From: Cameron Curtis
Sent: Tuesday, May 27, 2025 12:03 PM
To: chrisimmer islandchapel.net; Tate Mahre; Bradley Gasawski; Jamey Ayling
Subject: RE: 10 Jay way Hammer head

It sounds like you were able to speak with Tate, and I'll just echo some of the thoughts we have regarding the hammer head proposal. First, if you're proposing reducing the front yard setback, it's important that we really understand how that leg of the hammer head and your shop will work together. What you've shown in the attached photo is reasonable in conception, but if the shop and the turnaround overlap it creates issues with the turnaround. To ease my concerns, I'd really like to see both the building location and the turnaround drawn on a scaled drawing to verify there aren't any conflicts.

# PROPOSED SITE PLAN

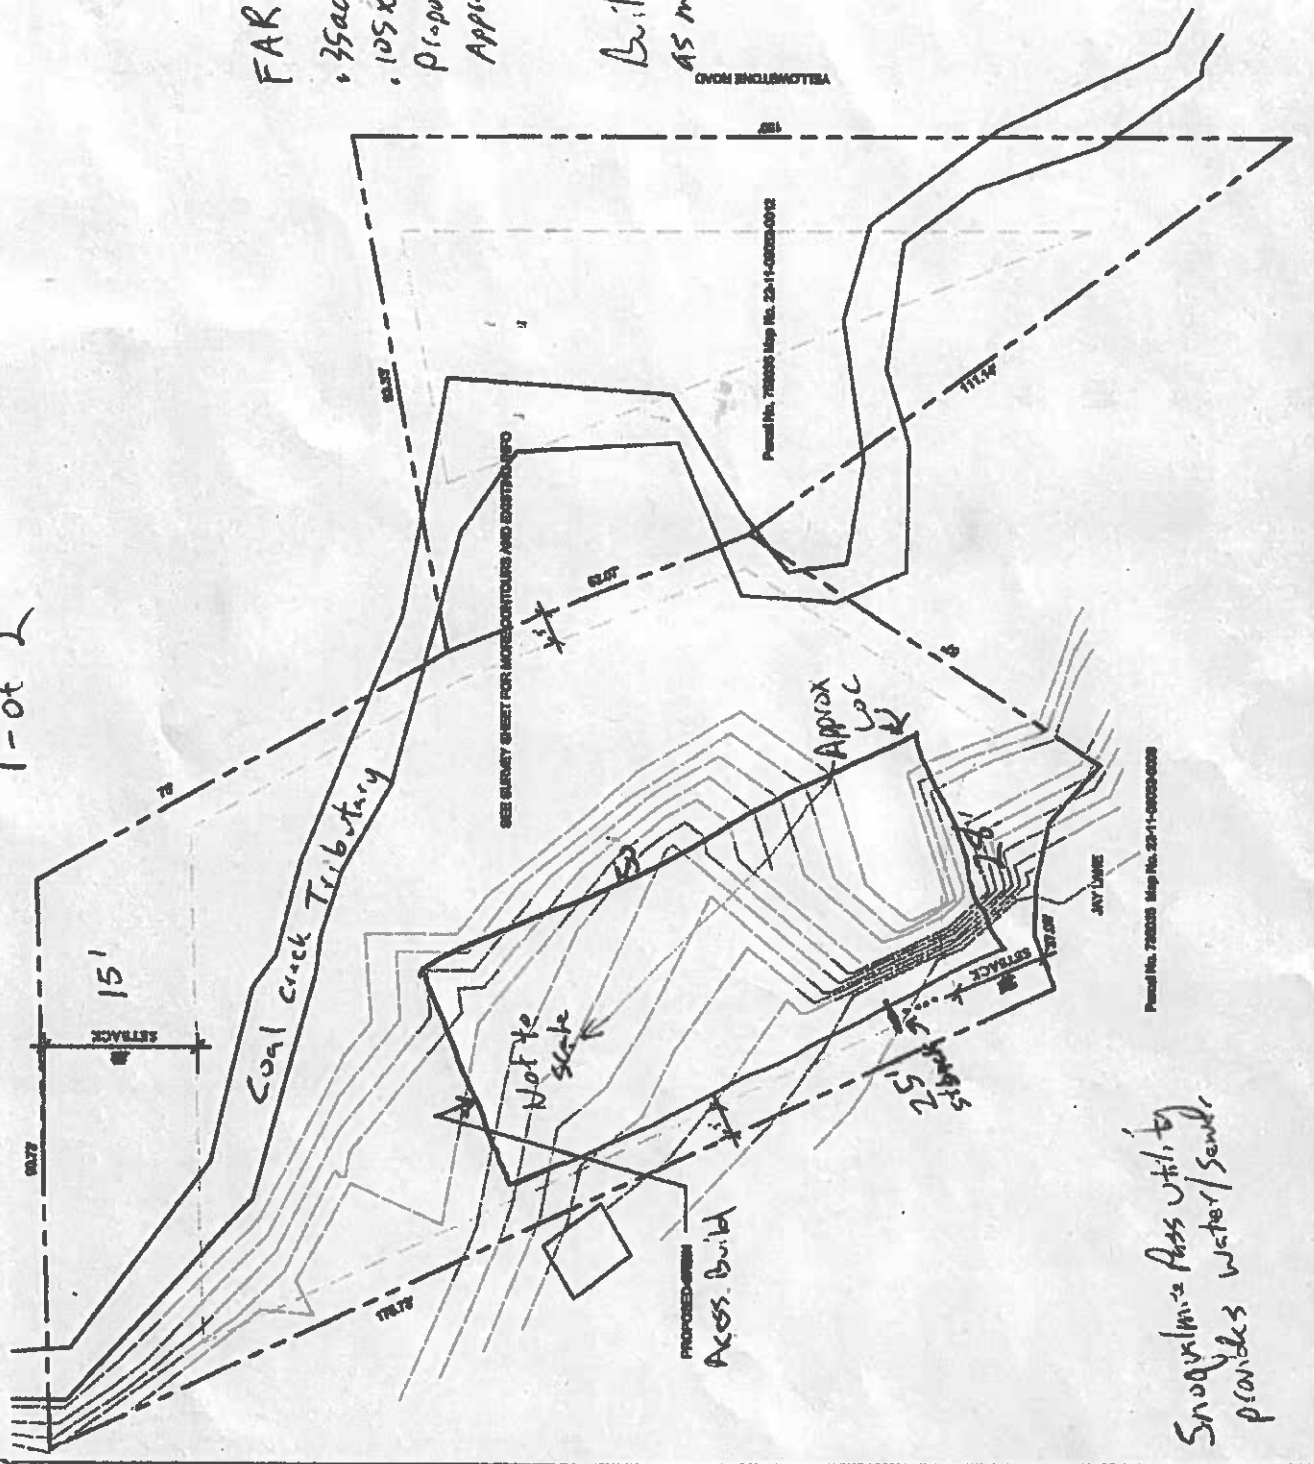
In the photo you have a note that all lot owners are okay with the turnaround going on their lots. Is it your intention to preserve the turnaround area within a permanent easement? I can understand you utilizing a portion of your driveway for the turnaround, but to use someone else's property, I think we'll need something a little more formal.

This photo also appears to show the leg on your property going over the steep portion of your lot. That would obviously require a lot of fill and might push your project over the 500 CY threshold requiring engineering and SEPA. We still haven't seen anything from encompass verifying quantities, so if this is the intention, please let us know. Otherwise, I think this again shows the importance of a scaled drawing.
